Lead Local Flood Authority

Date 12 December 2023

RE: FP/274/21/OUT – Bognor Regis Golf Club, Downview Road, Felpham

Following a review of the submitted information we **object** to this planning application in the absence of an acceptable Flood Risk Assessment (FRA) & Drainage Strategy relating to:

© WSP Global Inc

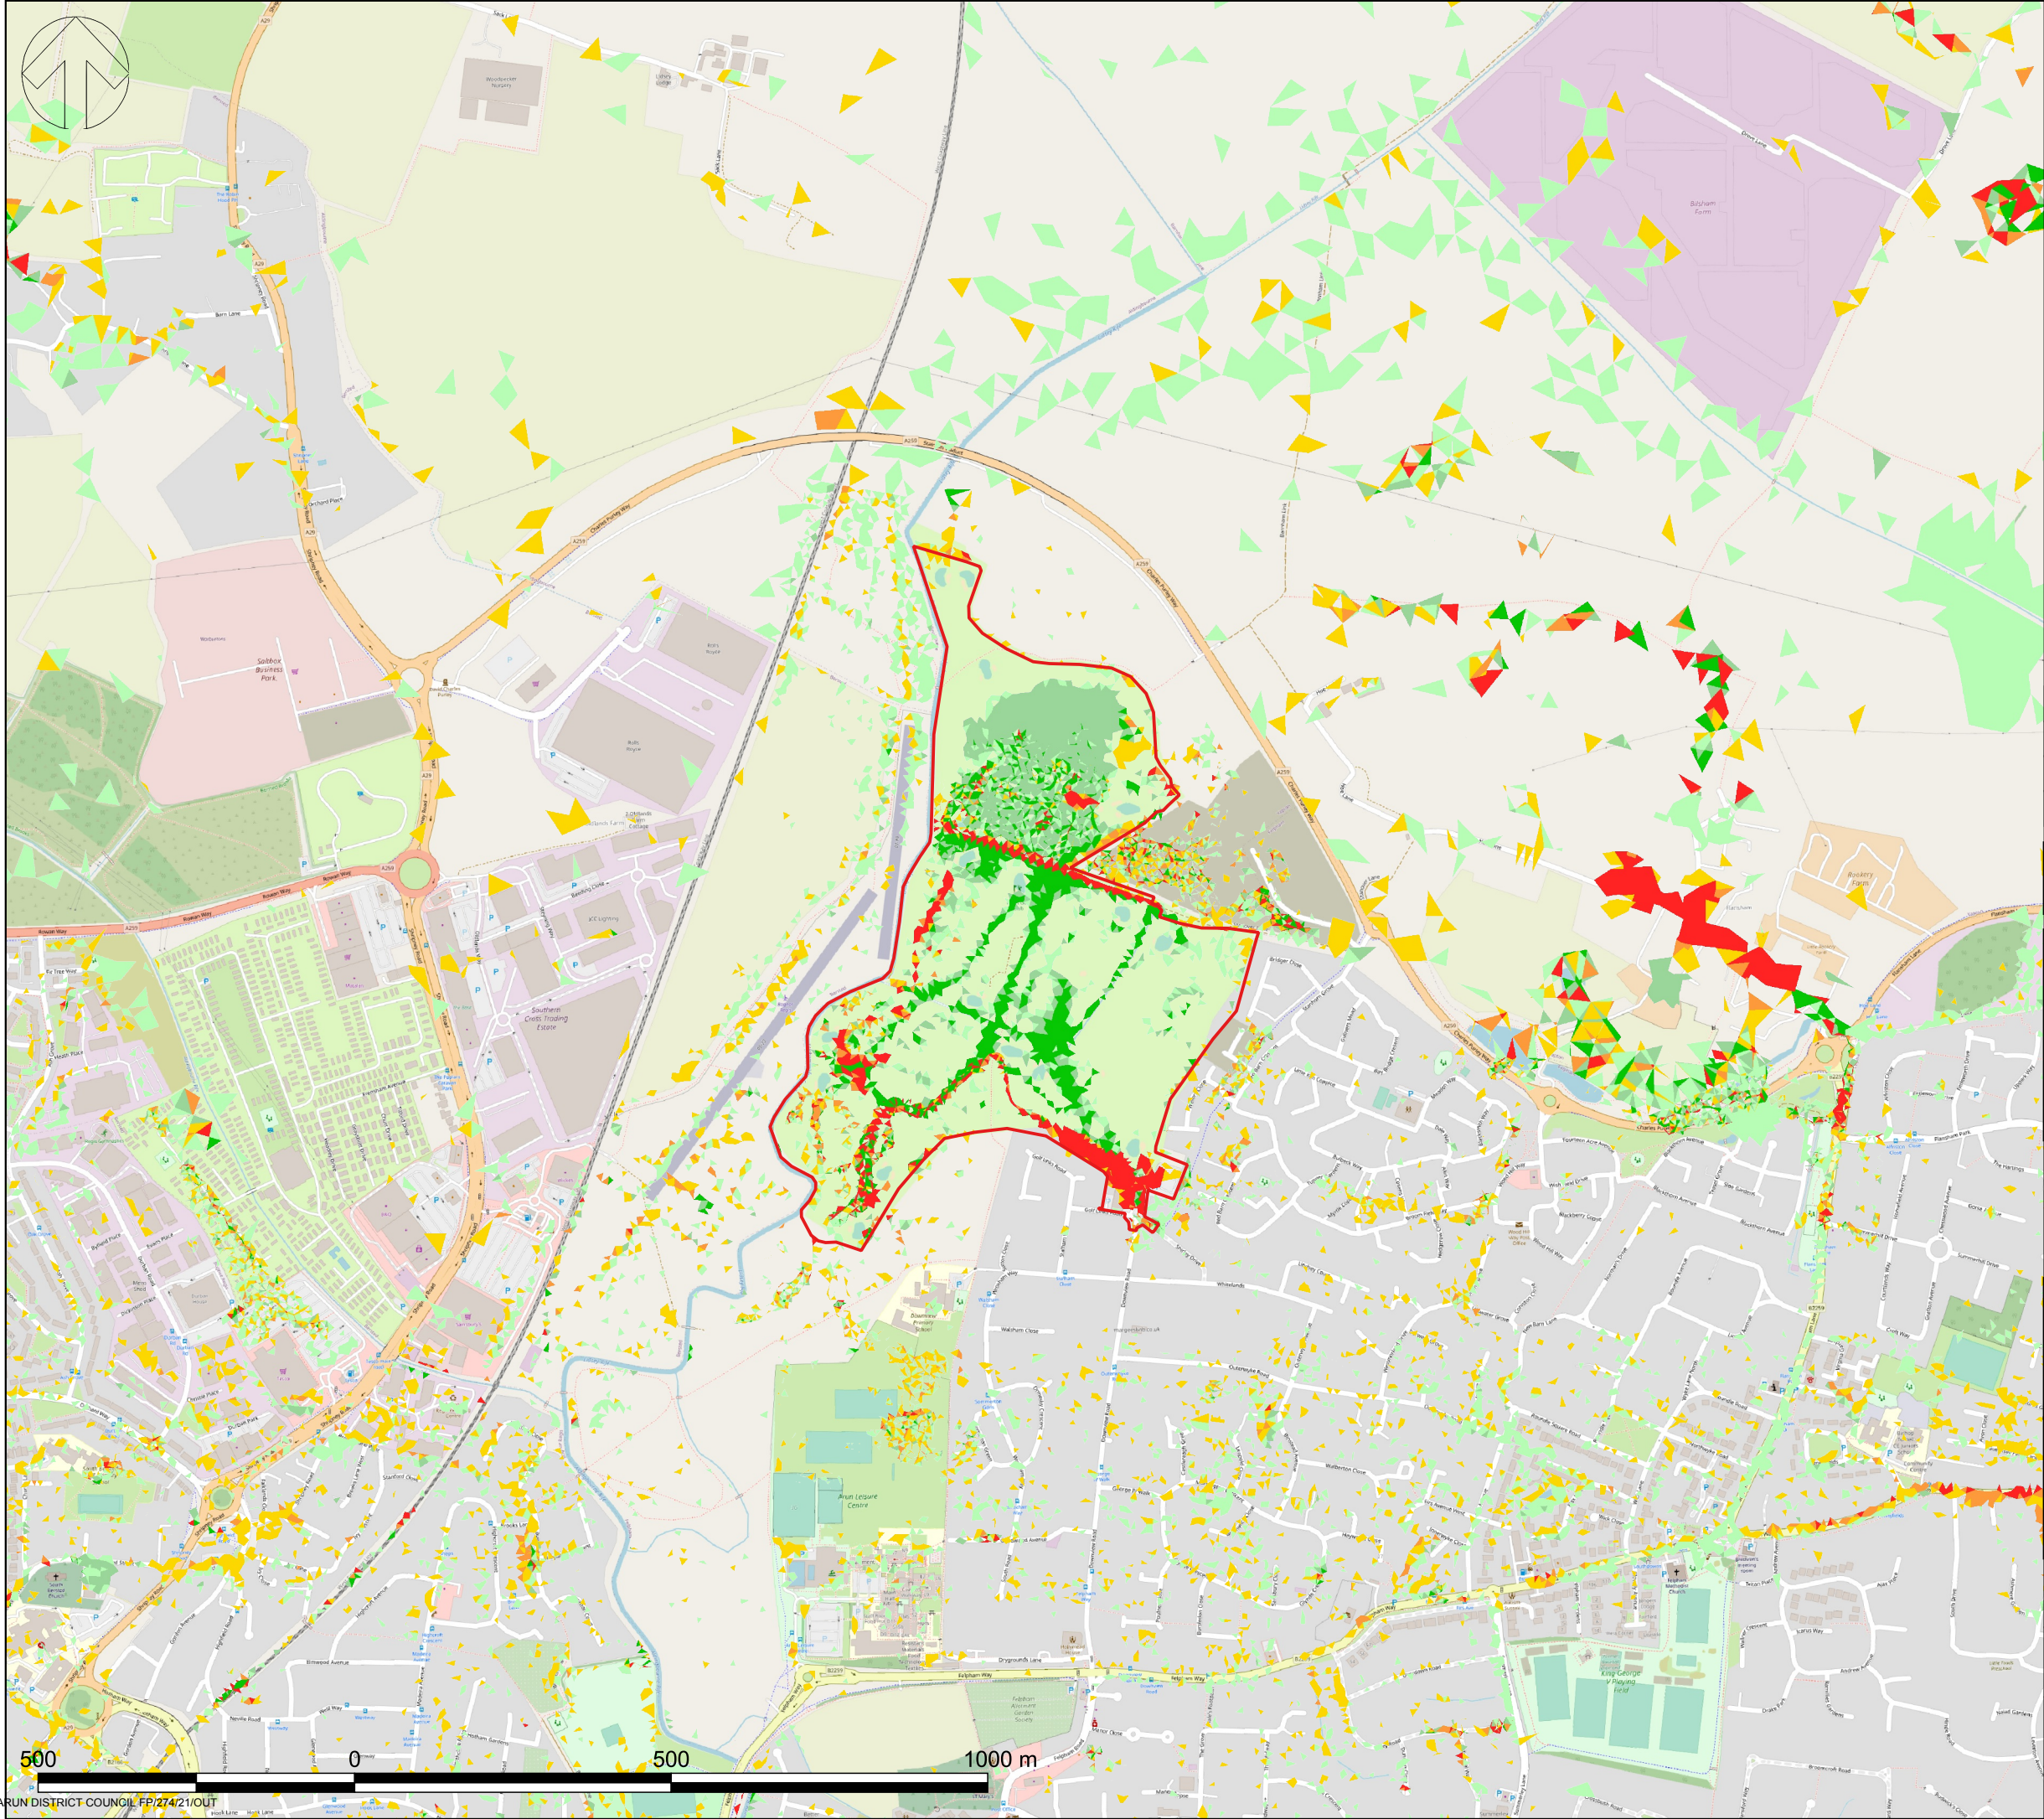
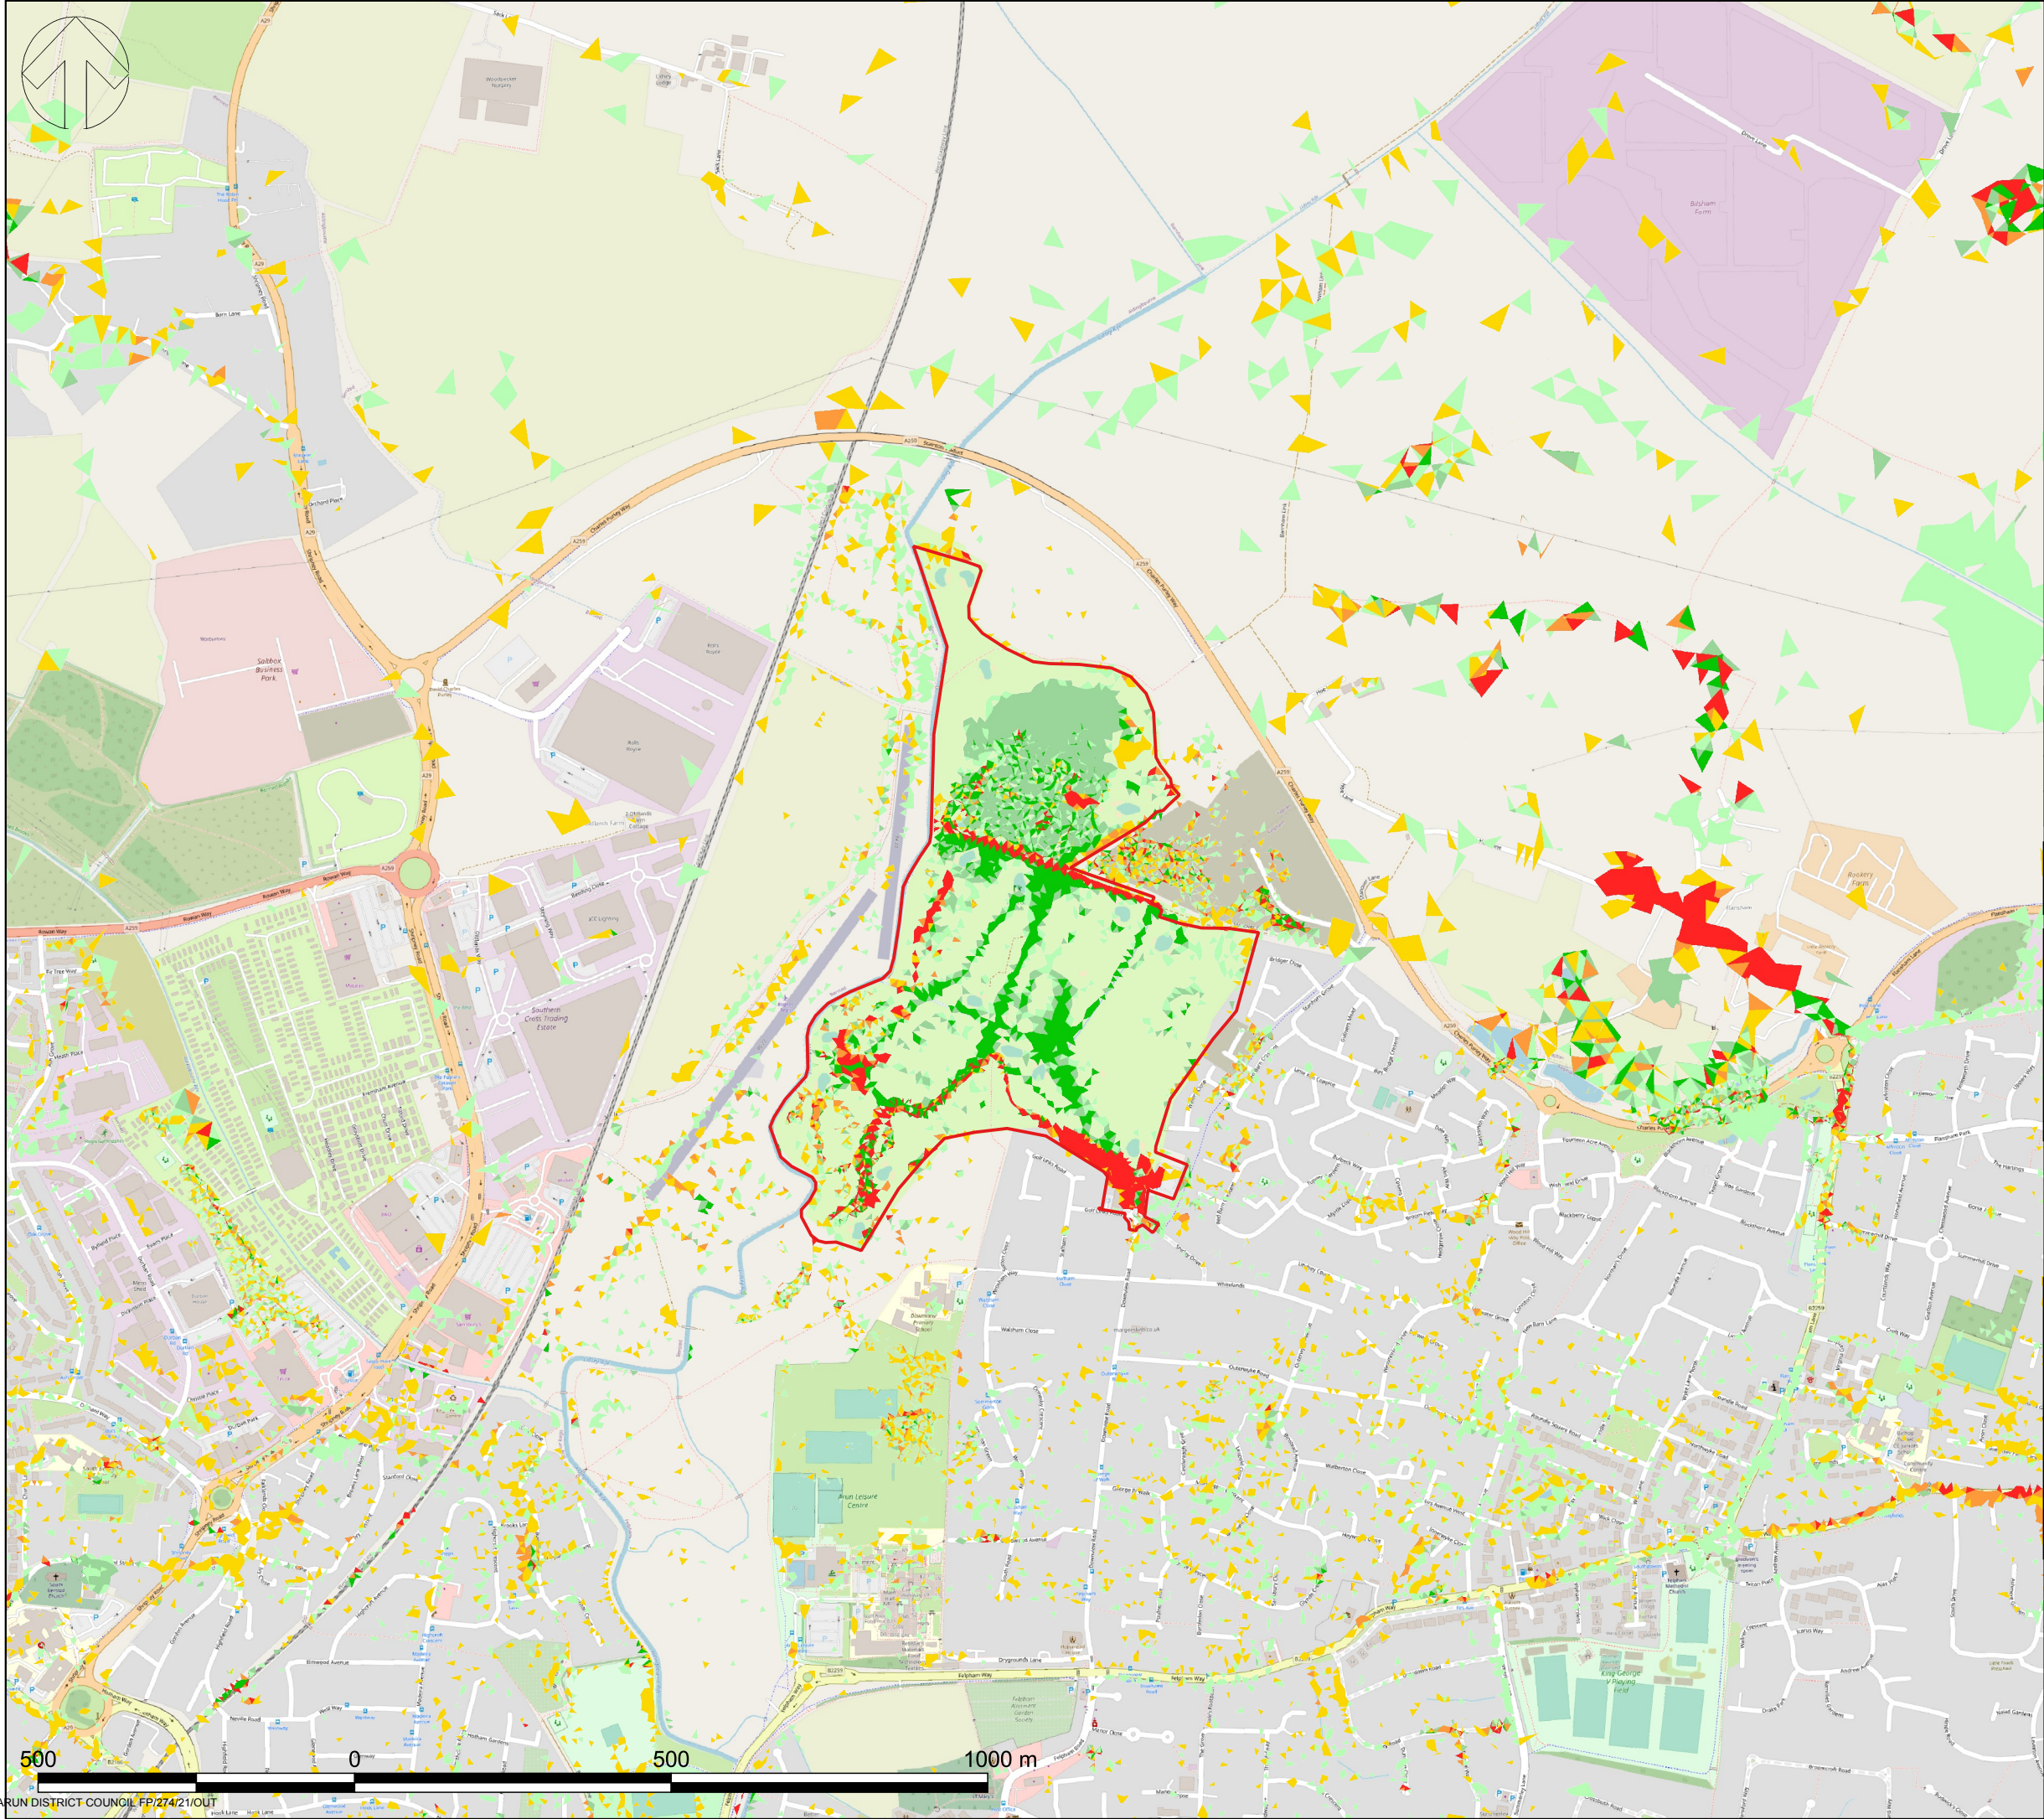
The original information does carry out further modelling however this concentrates on the fluvial flood risk and existing channels and is not detailed enough to clarify the Surface water flood risk to the site. It is also noted that the additional hydraulic modelling only utilises a 25% increase for climate change, in relation to surface water flood risk this should be increased to 45% as it's the current standard. The model will need to be updated to assess the surface water flow paths coming through the site and not only those represented by the channels. It is not appropriate to use out of date data at the time of determination of a planning application and hence an update was provided when the NPPF PPG was updated in the form of a technical note however the applicant has failed to update the climate change allowances and modelling parameters which are also out of date at this present time and therefore underestimates the risk of flooding to the site. The modelling and assessment also needs to demonstrate that there is no development within the 1 in 30 (3.33%) AEP for both surface water and fluvial as this is now considered the Functional Floodplain with NPPF since the update in August 2022.
